Re: Detailed Roadway Traffic Noise Assessment
Westgate Shopping Centre Development, Phase 1
GWE File No.: 15-067 – Cover Letter

This letter describes how we have addressed the 1st round of engineering comments received from the City of Ottawa, in their memo dated January 14, 2019 pertaining to the Detailed Roadway Traffic Noise Assessment performed for Phase 1 of the proposed Westgate Shopping Centre redevelopment in Ottawa, Ontario. Below is a summary of how each of the comments relating to the noise study have been addressed. The number sequences below are in reference to each of the numbered comments continued in the City of Ottawa's comment letter.

5TH FLOOR PLAN

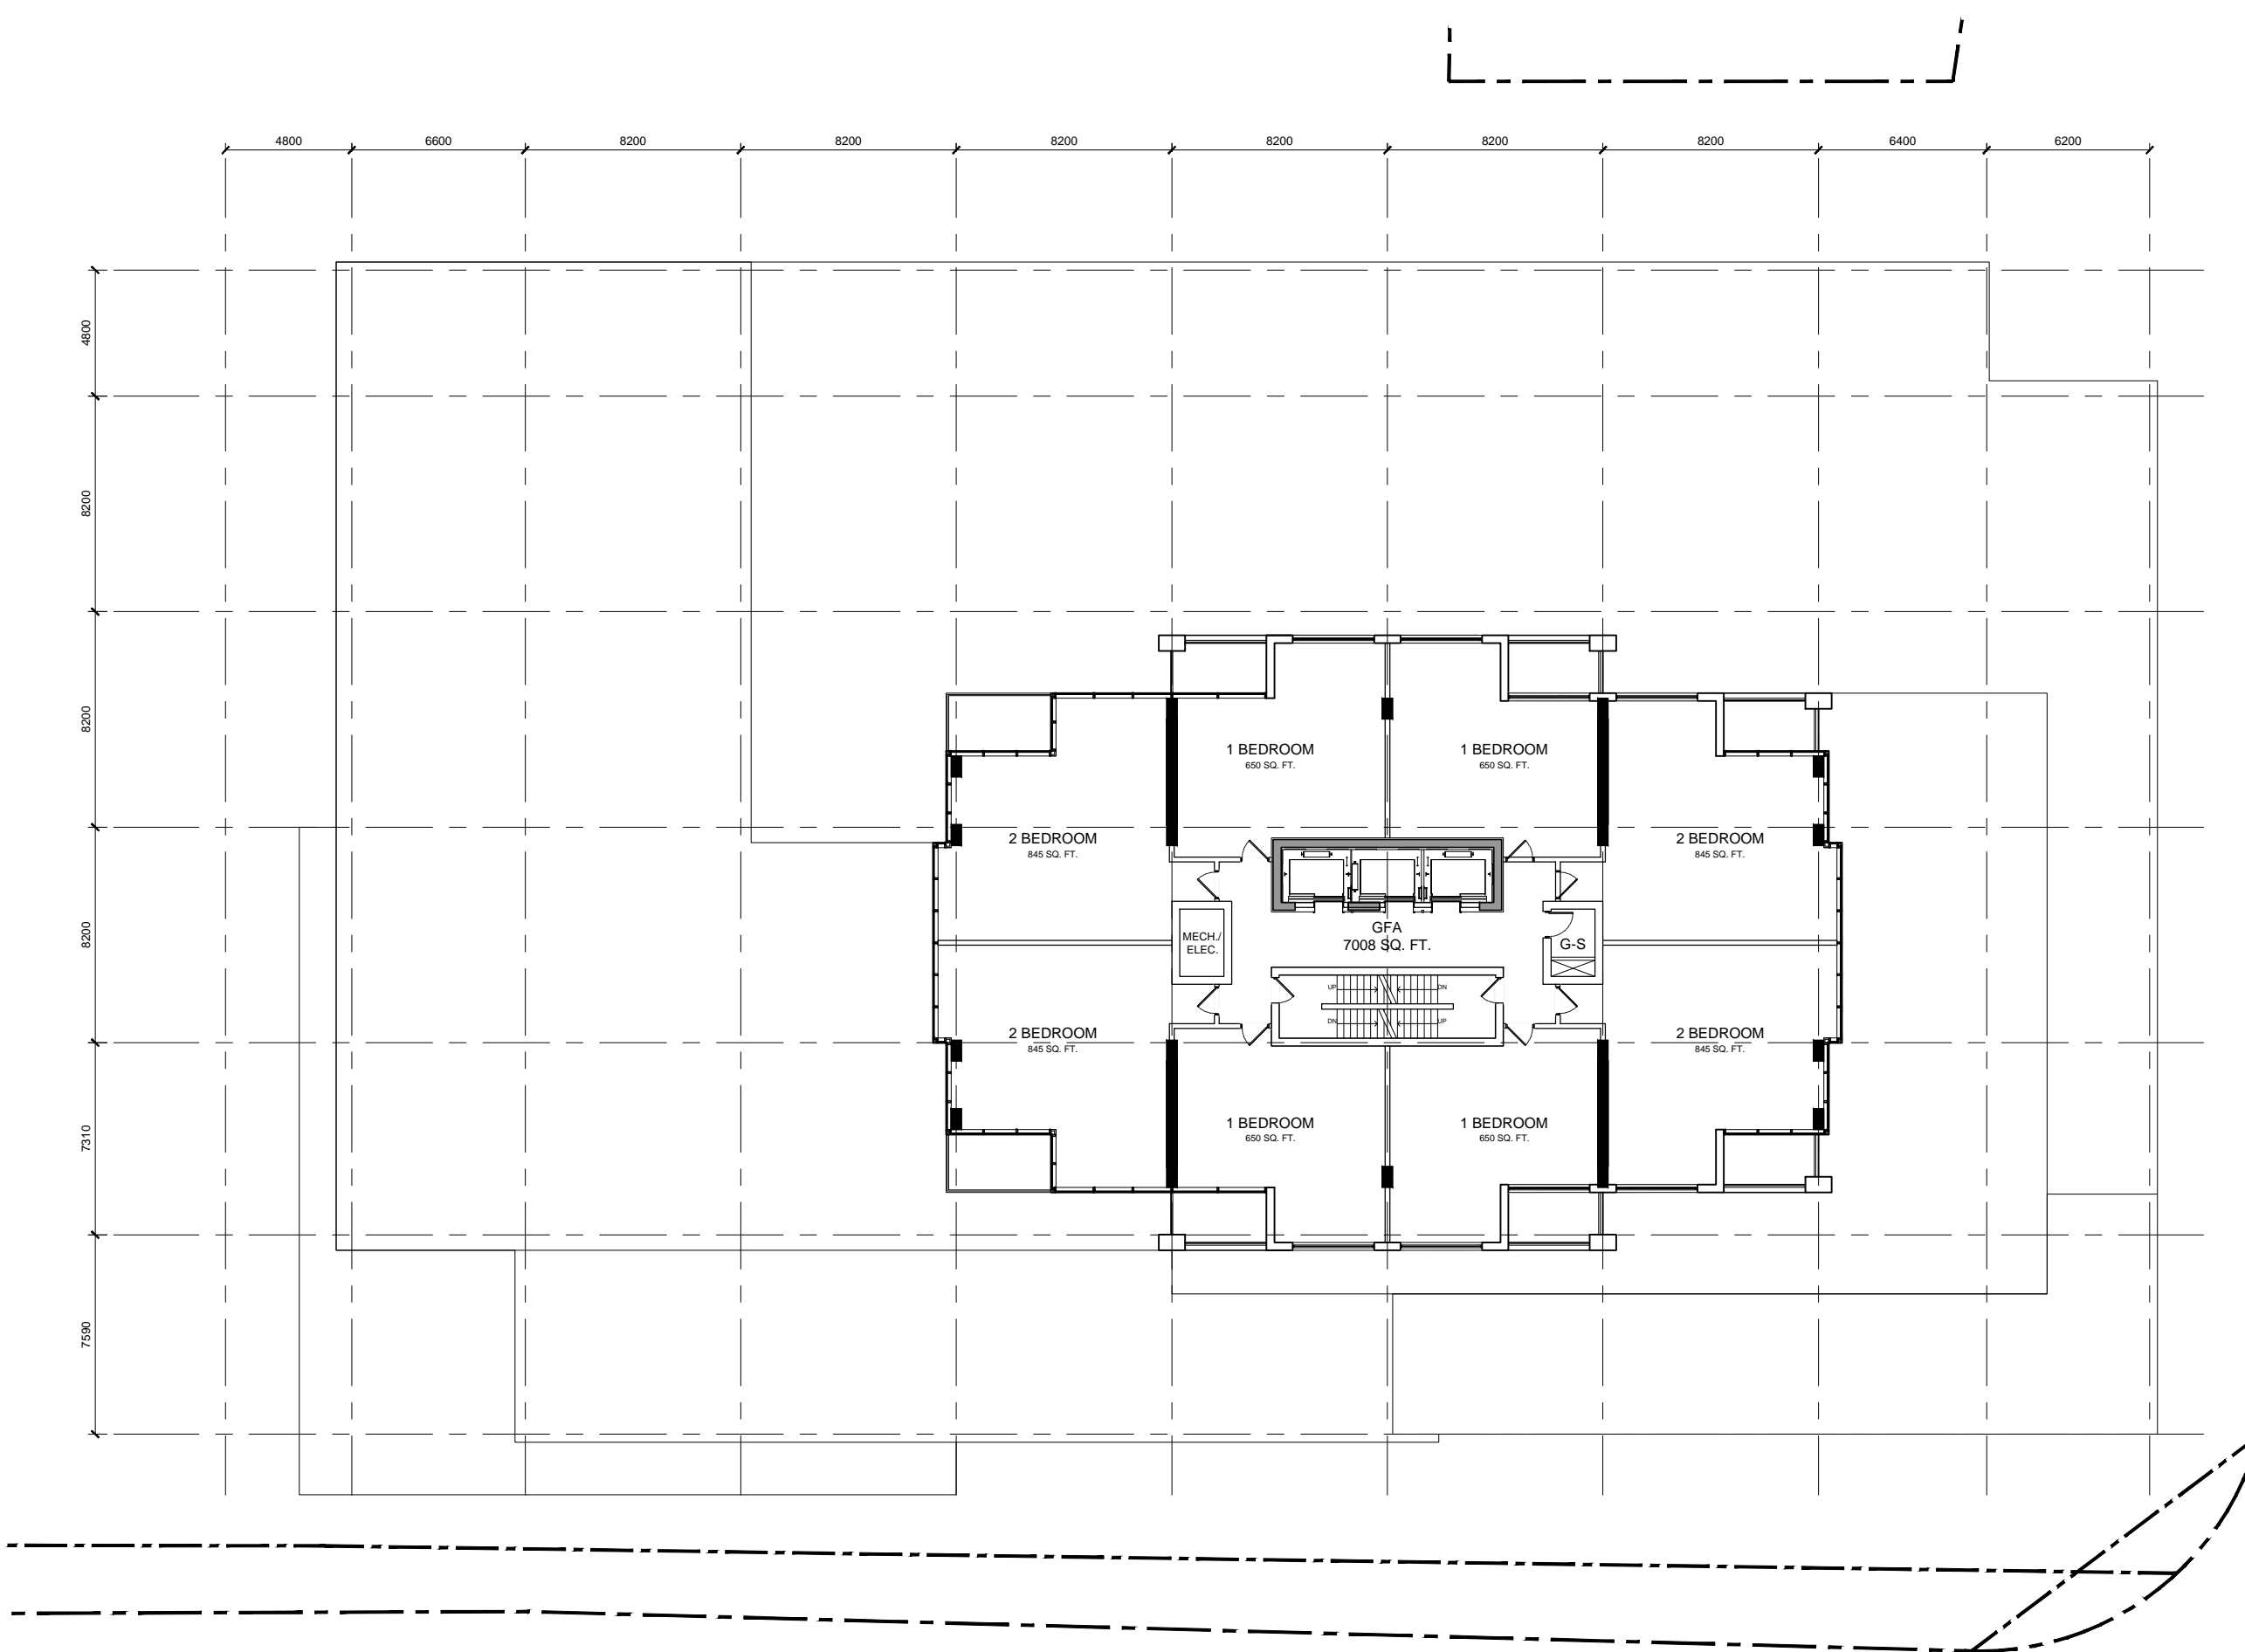
7. Report does not provide investigation information and recommendations for the proposed 5th floor outdoor amenity area. If mitigation were required in regard to Outdoor Living Area Mitigation Solutions, we would also require detailed shop drawings and material specifications for sufficient soundproofing as per methods AIF or OBC (STC). Please add these criteria. Please refer to **Pedestrian Level Wind Study**, prepared by Gradient Wind Engineering Inc., dated November 6, 2018. Revise.

GWE Response: Barrier investigation has been added to the report/analysis.

ROOF PLAN

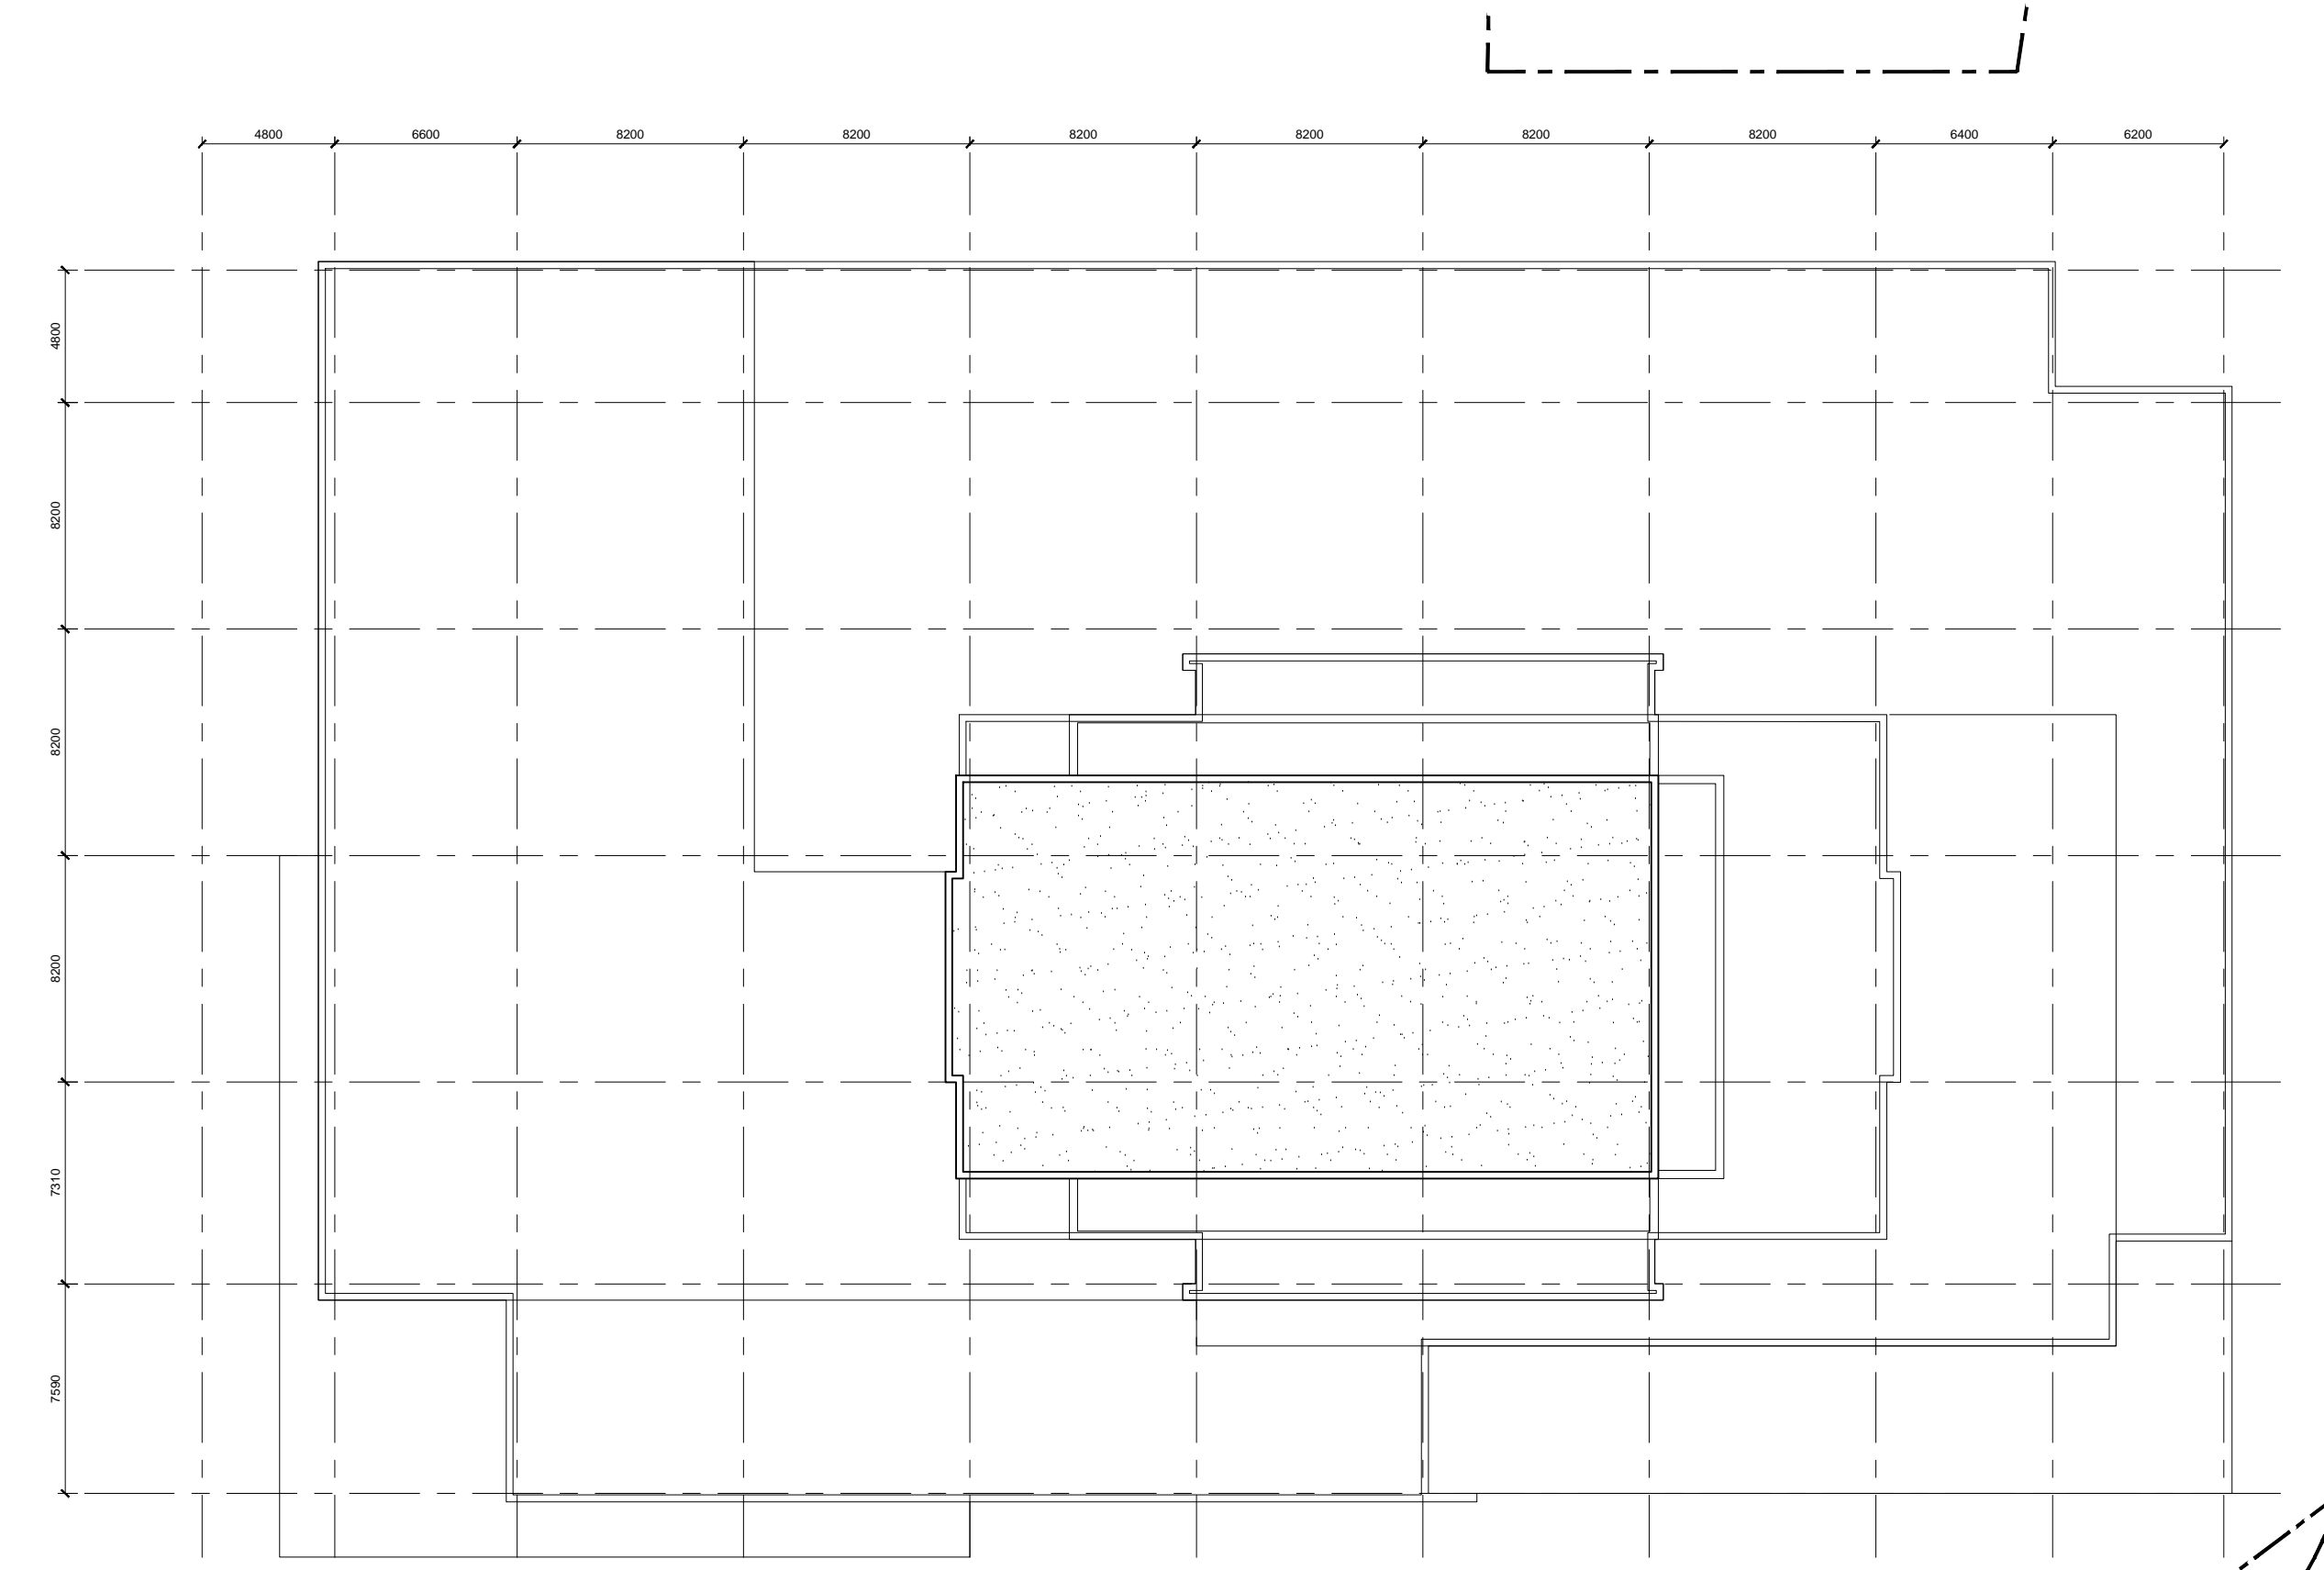
8. *A stationary noise study is required to determine the affects of all proposed roof (or other level) top units for this building as this noise may subject the tenants/owners of the upper level of the residential building.*

GWE Response: The need for a stationary noise study has been addressed within the report. Once the mechanical information is more known, this type of study would be conducted prior to building permit.

Figure 17: Landscape Plan

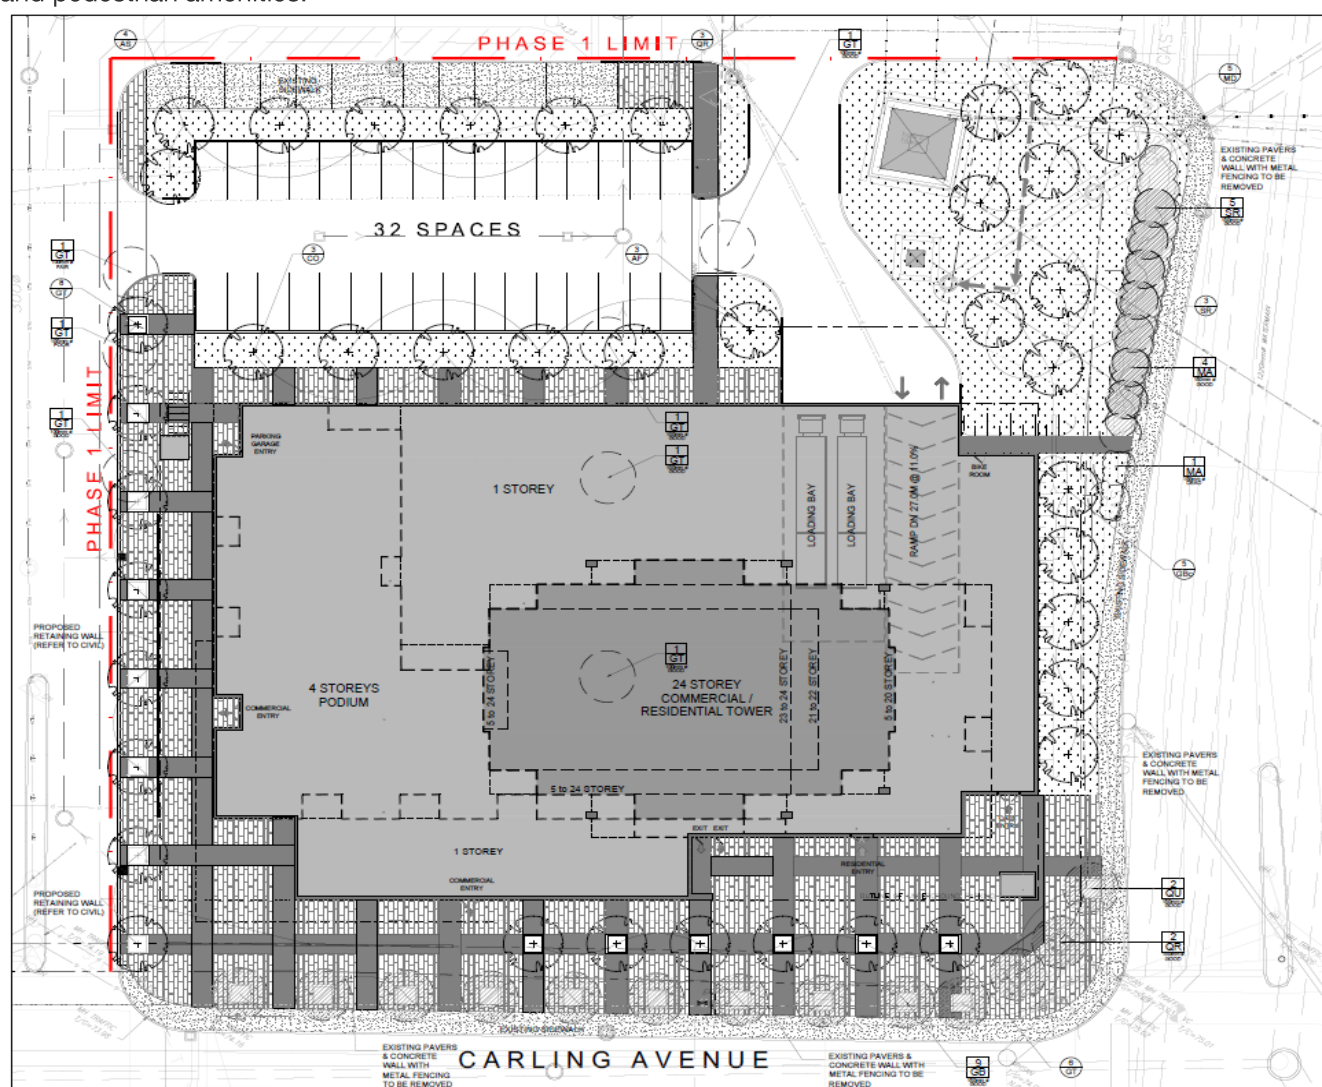
6. Please confirm and show that upper floors will not be affected by reflective noise from proposed hard landscapes planned around majority of the building, nearby parking lot pavement surfaces and concrete sidewalk areas adjacent the proposed building and within the ROW. First floor level should have lower noise levels with absorptive ground surface. Verify % soft ground & % reflective surface as per ORNAMENT. Refer to Landscape Plan, Revise.

GWE Response: Section 4.2.2 has been updated to provide rationale for reflective surfaces.
